WATERVIEW NORTH

COMMERCIAL ZONE - CS

LOCATED IN A PORTION OF SECTIONS 8 & 9,
T15S, R65W OF THE 6TH P.M.,
EL PASO COUNTY, COLORADO

PROJECT NUMBER:	0219-05
SHEET	1 OF 2

COMMERCIAL ZONE - CS

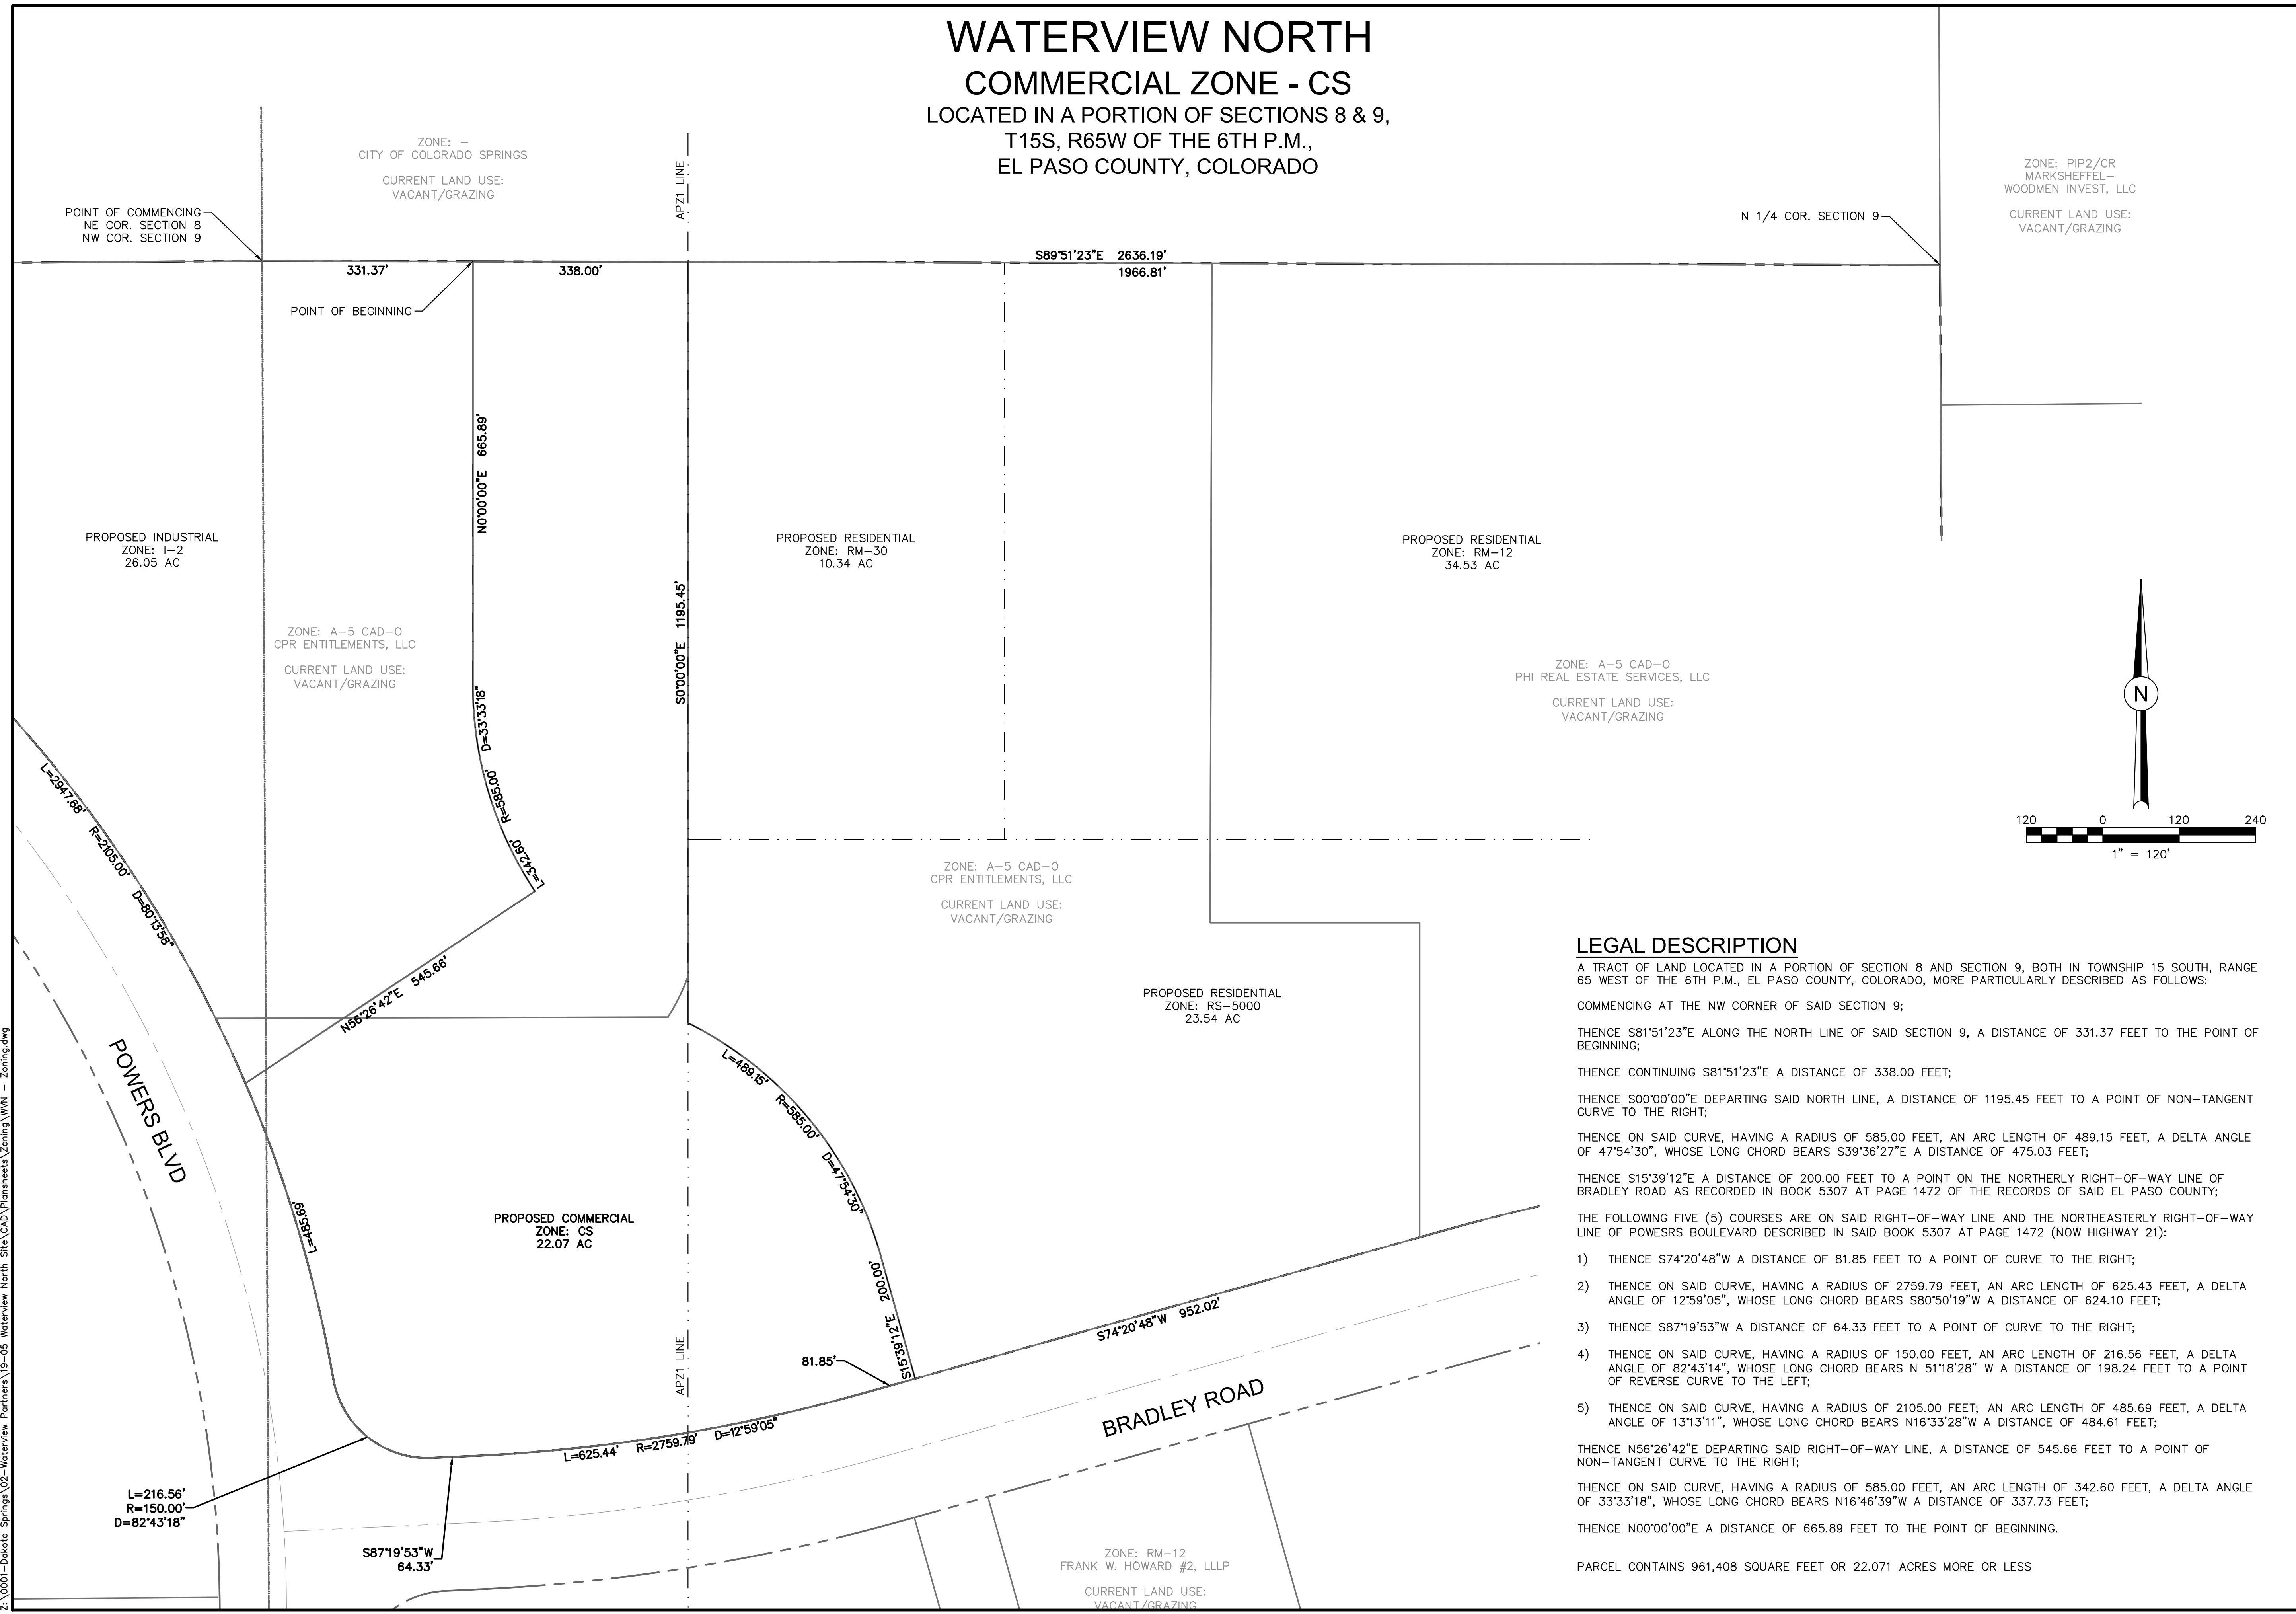
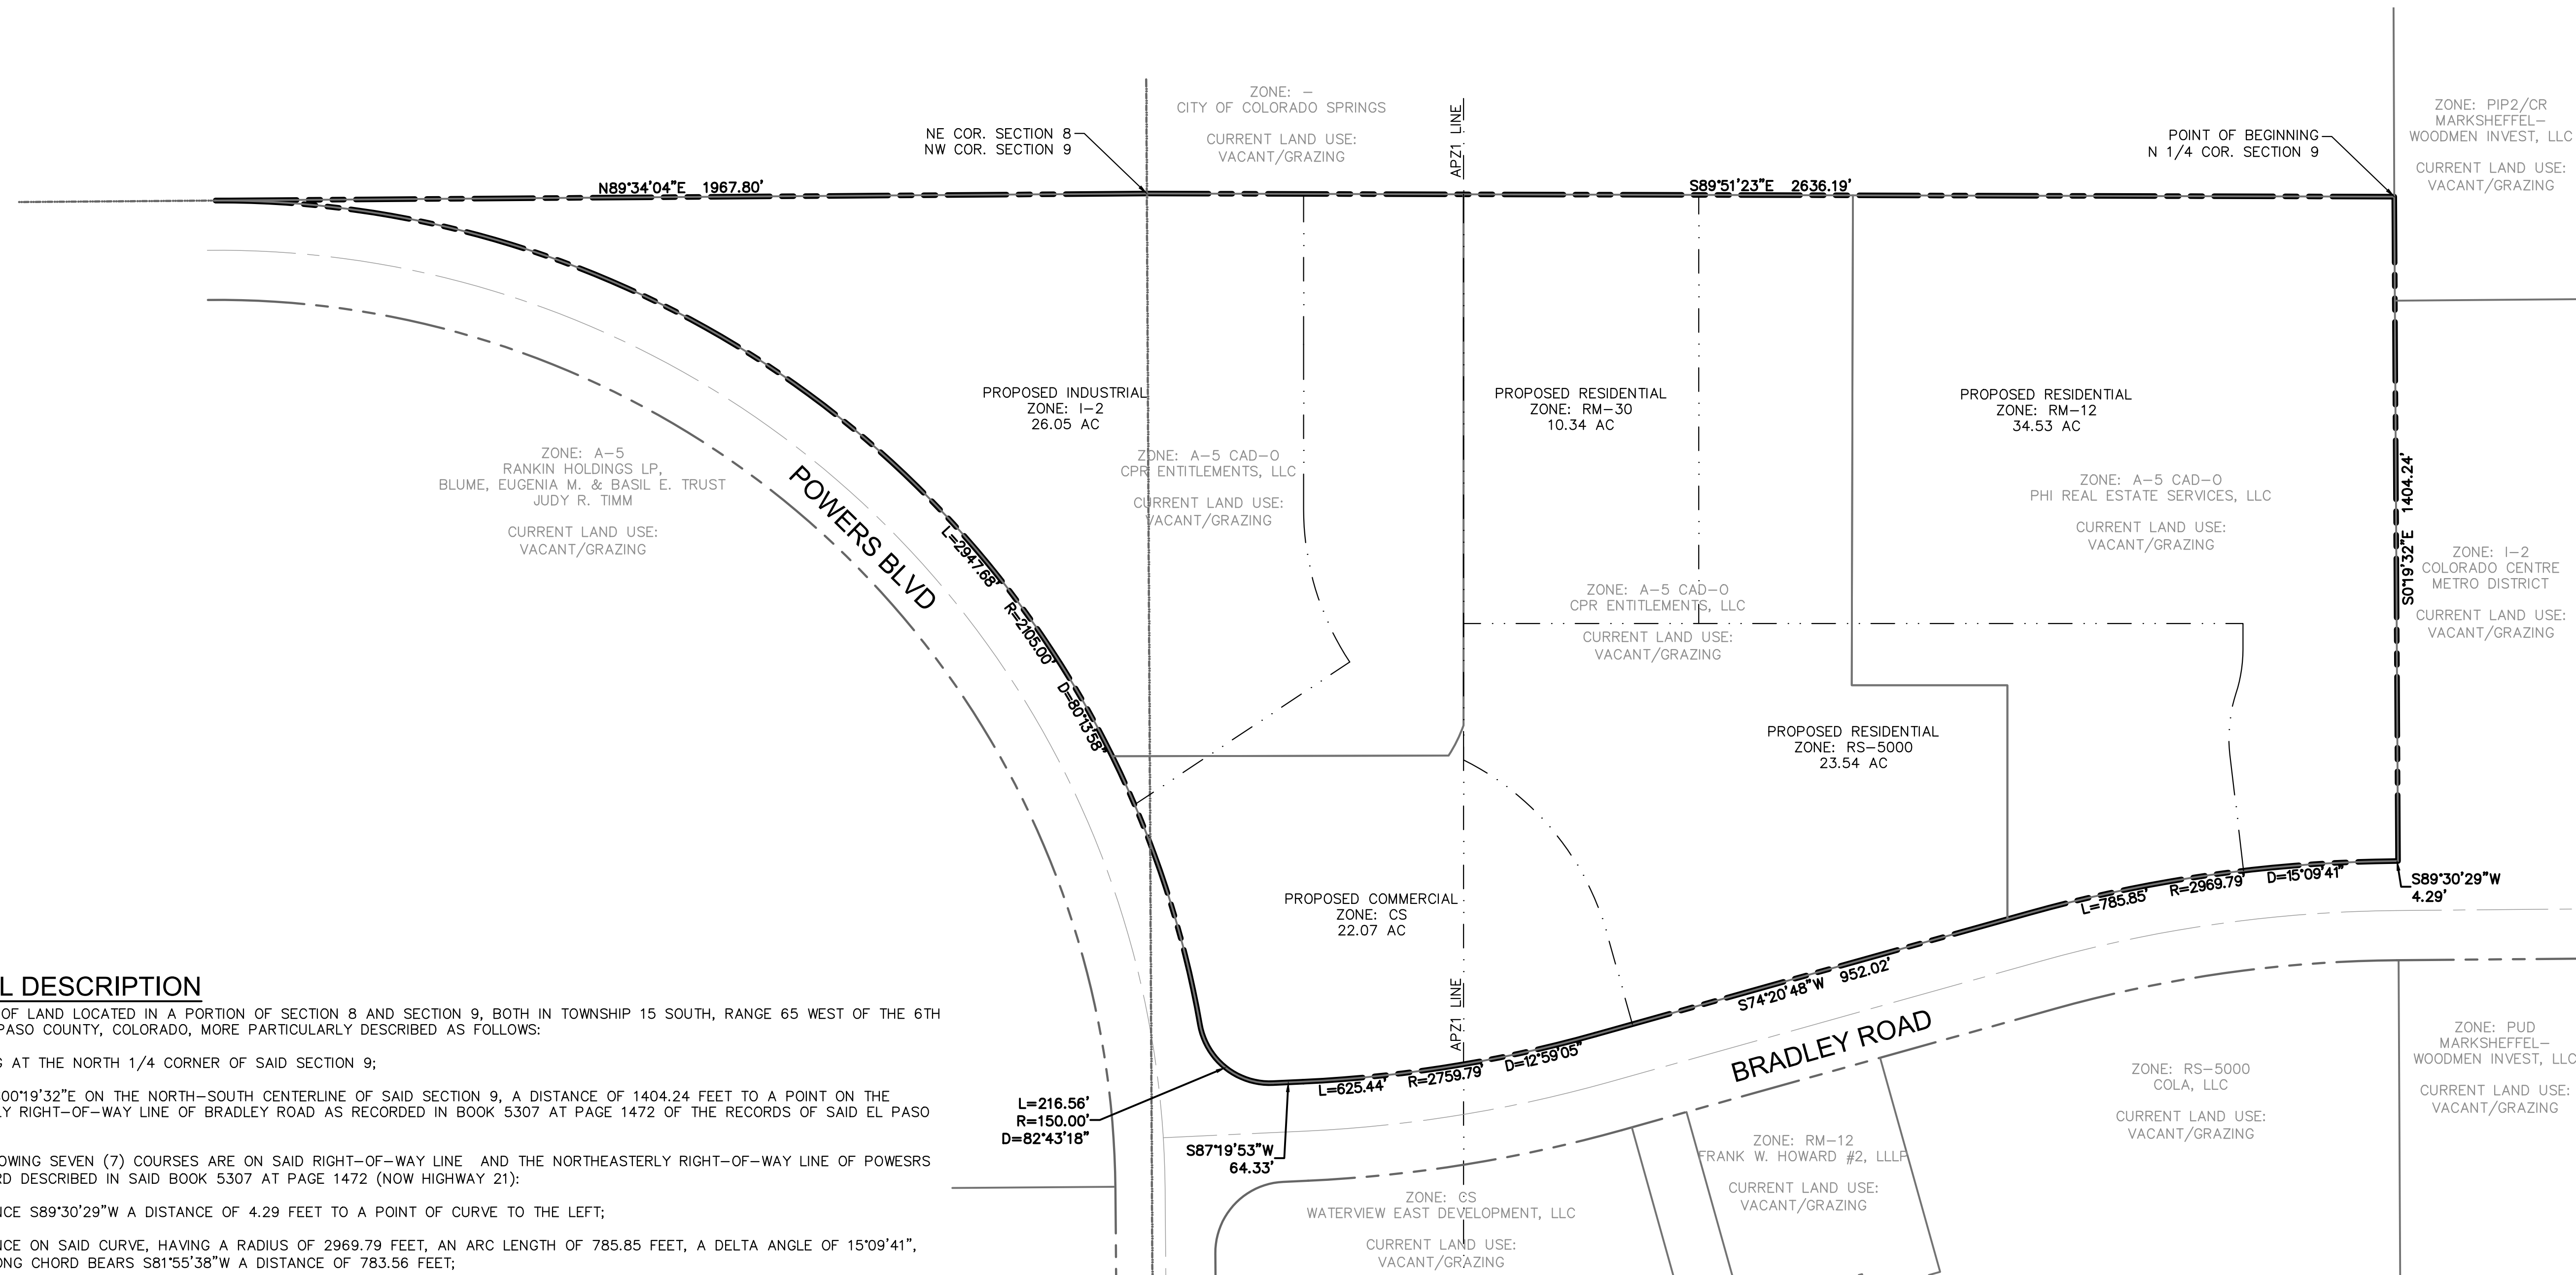
please add legal description for property you are rezoning

please bold border of parcel you are rezoning so we know what parcel/area you are rezoning (comment applies to both pages of this document)

-please add adjacent property ownership
-please add existing easements to document
-please add the name, address, phone number, and email address for property owner and applicant

please add dash lines to legend so we know what they mean

Please clearly identify existing parcel lines and the area to be rezoned with this request. The parcels, dashed lines, and zoning designations as shown are confusing and not clear
